KIRKLEES METROPOLITAN COUNCIL INVESTMENT & REGENERATION SERVICE

DELEGATED DECISION TO DETERMINE APPLICATIONS FOR LISTED BUILDING CONSENT

Reference No:	2026/65/91370/W
Site Address:	George Hotel, St George's Square, Huddersfield, HD1 1JA
Description:	Listed Building Consent for internal works to allow the installation of a temporary staircase (to facilitate construction works in association with the refurbishment and redevelopment of the George Hotel and its coming into operational use to provide 108-bedroom hotel with bar, restaurant, gym, conference facilities and ancillary facilities, approved under previous Listed Building Consent application reference: 2025/91148 and previous planning permission reference: 2025/91147) (Listed Building within a Conservation Area)
Recommending Officer:	Jillian Rann

Application: 2026/91370

2 Level 02 - Haki Stair Demolition Plan  
1 : 100

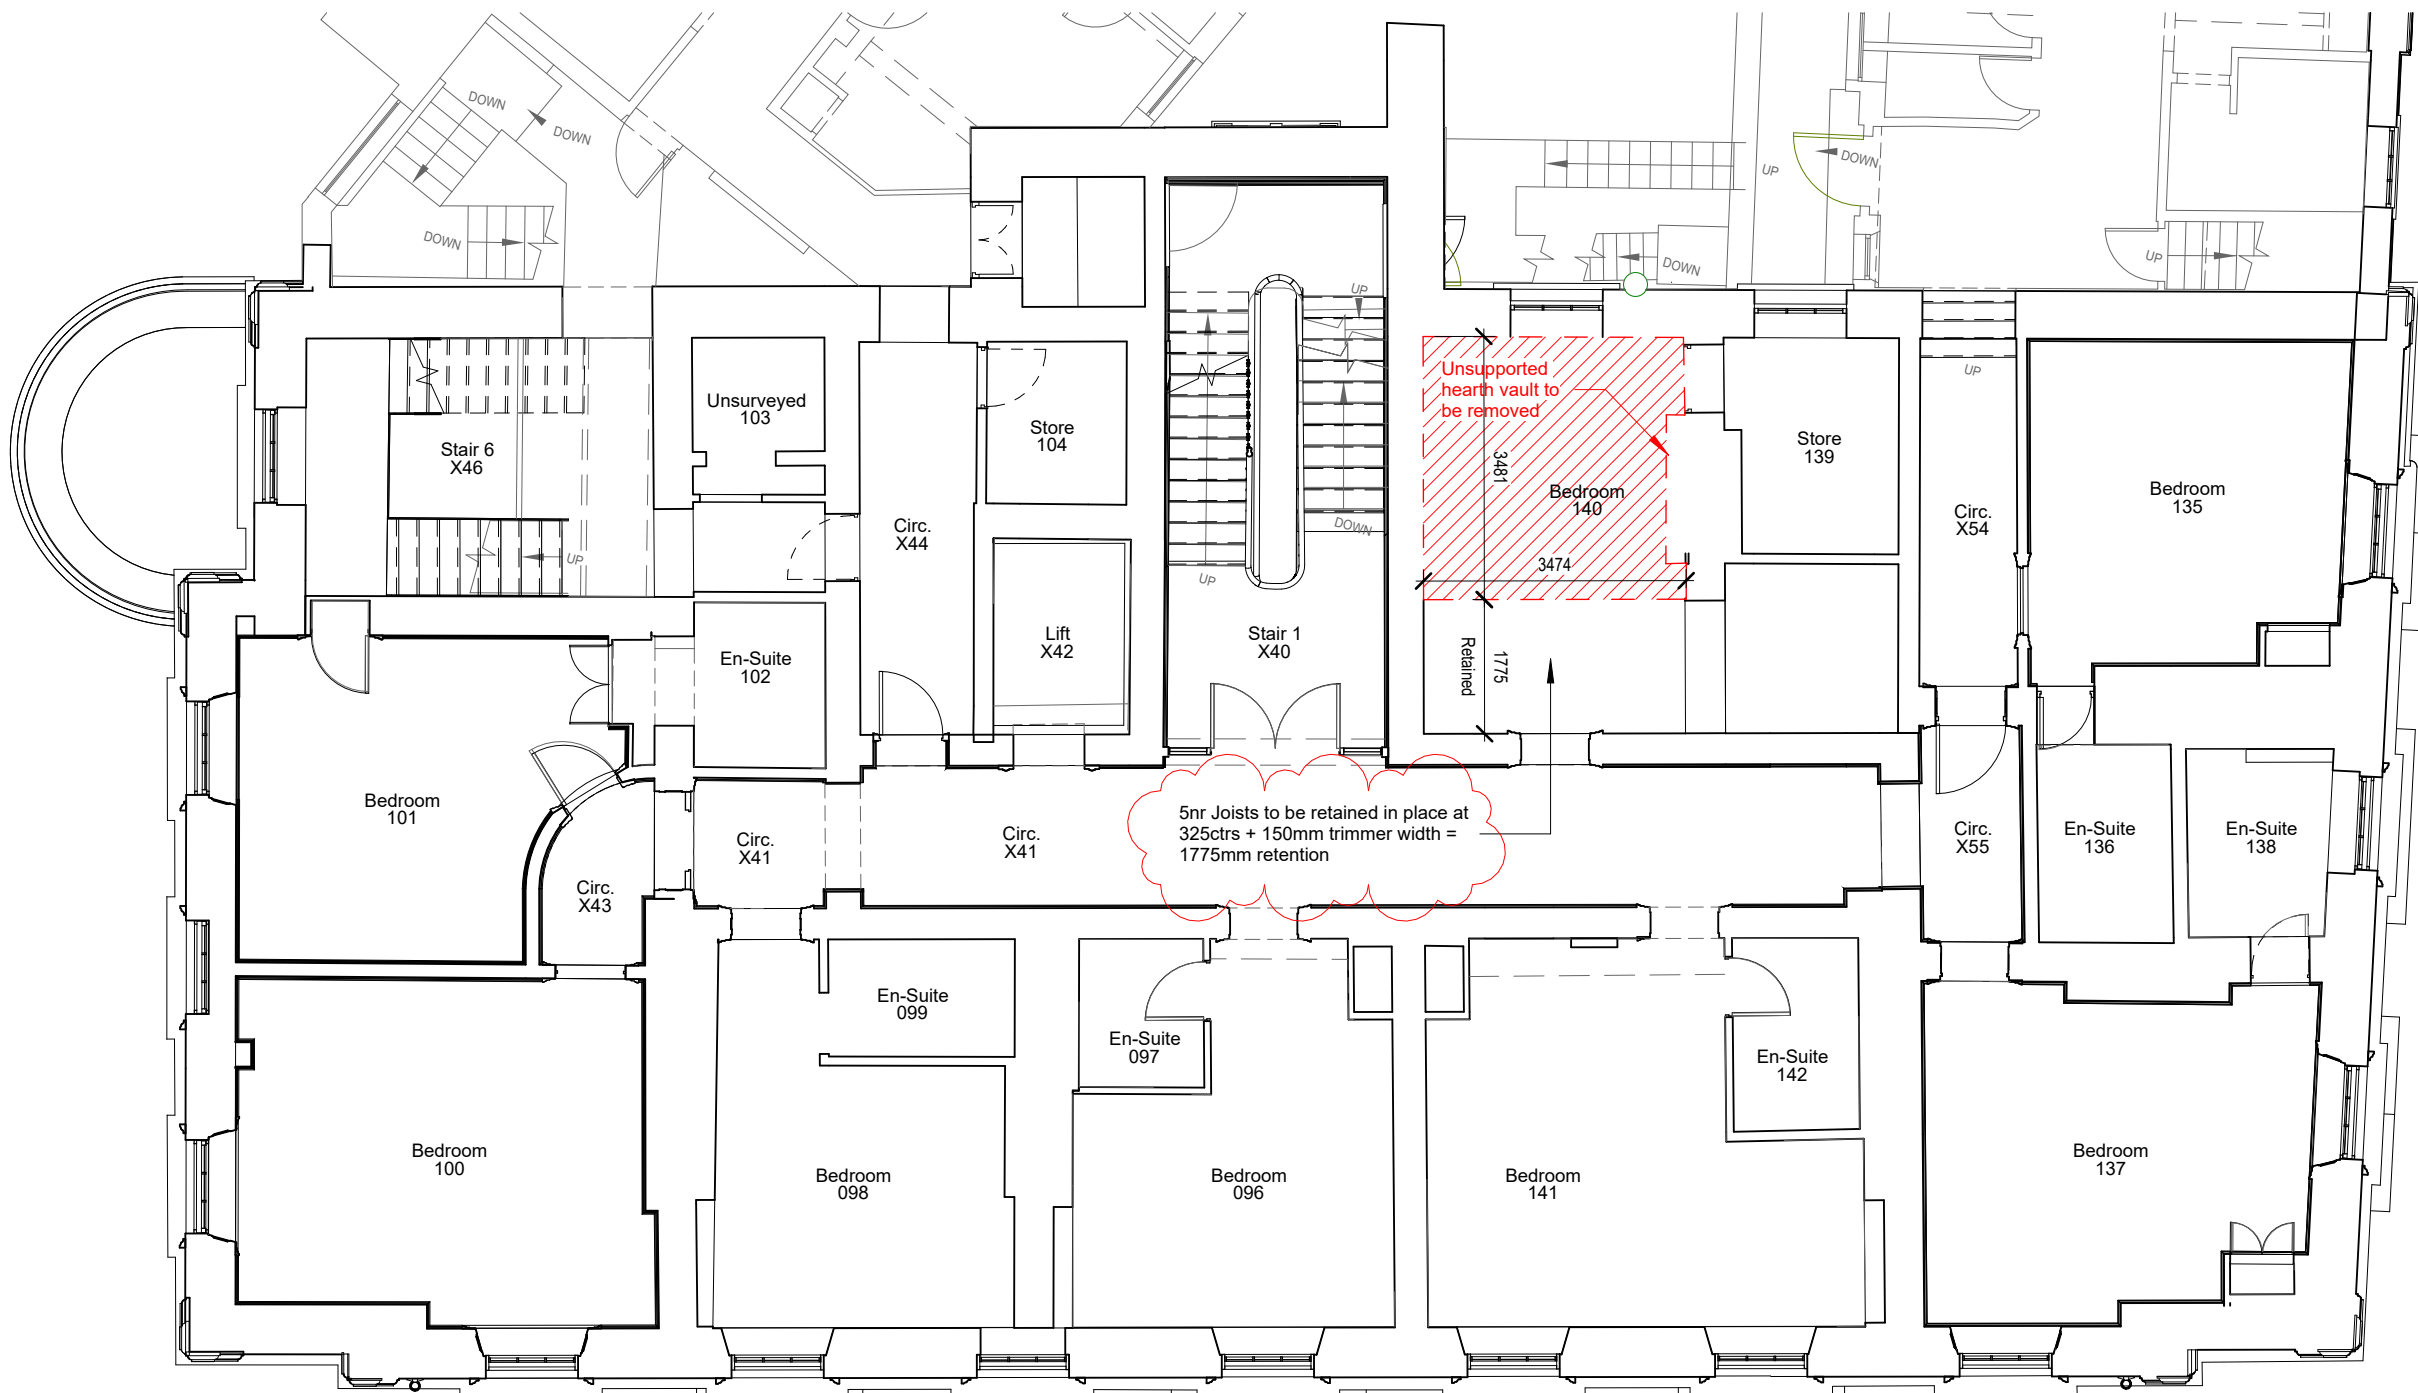
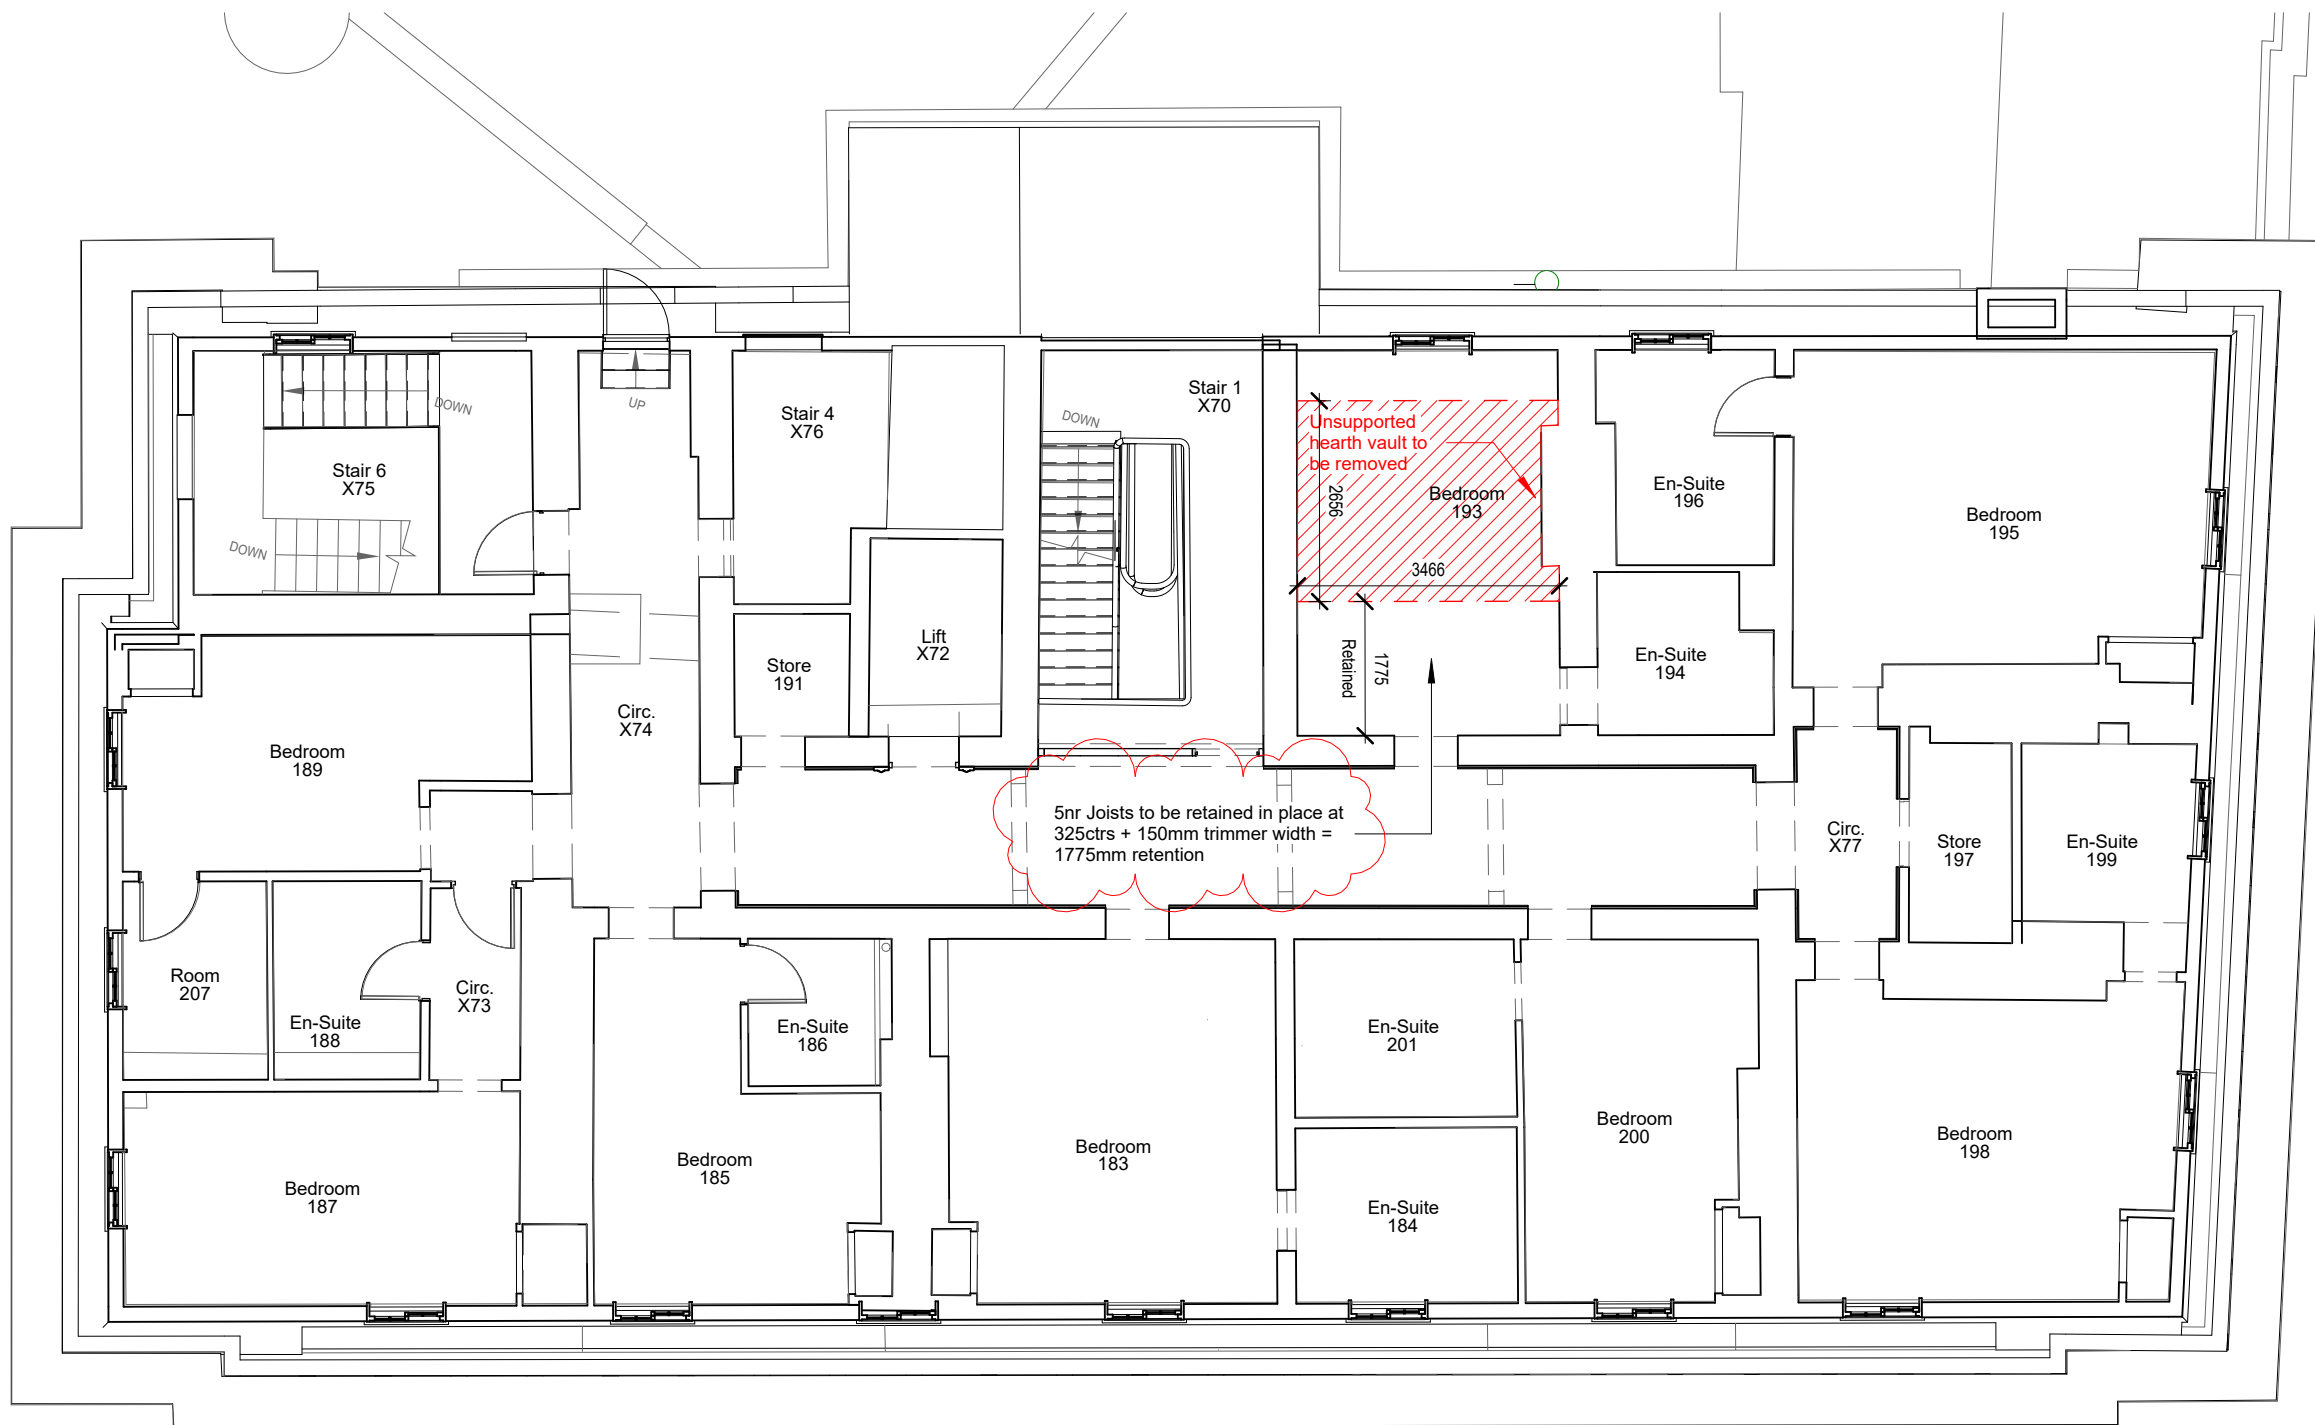
The revised plan now shows the removal of a smaller area of floor/ceiling from several of the relevant rooms than was originally proposed, and states that

several joists are proposed to be retained in place near the entrance to each of those rooms.

Officers raised queries with the applicant about whether the proposed removal of the floors from the relevant rooms would have any implications for the

stability of the historic staircase within the existing building (which adjoins those rooms). Clarification was also sought about whether it was proposed to remove the full extent of the floors/ceilings from those rooms, or only parts of those floors/ceilings.

In response, the applicant has submitted a revised Demolition Plan, which shows the retention of part of the floors/ceilings closest to the entrance to each of those rooms. A 'Wall Stability Statement', prepared by a Structural Engineer, has also been received, which includes a proposal for the HAKI stair to be fixed to both walls to provide lateral restraint. A further updated Wall Stability Statement has subsequently been received, which includes further information about the sequencing of the proposed works, in response to queries from the case officer in that regard.
